CITY OF PORTLAND

BUILDING PERMIT

Job ID: 2012-09-4952-ALTCOMM

has permission to make 920 sq ft of office space within the warehouse area as per plans provided that the person or persons, firm or corporation accepting this permit shall comply with all of the provisions of the Statues of Maine and of the Ordinances of the City of Portland regulating the construction, maintenance and use of the buildings and structures, and of the application on file in the department.

**HANDICAP RAMP**  
NOT TO SCALE

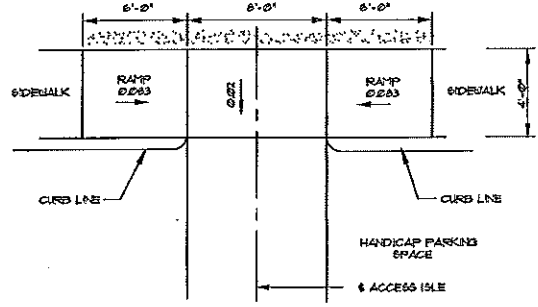
The exterior stair and ramp are new and shall comply with the requirements for new. Both shall have proper handrails on both sides.
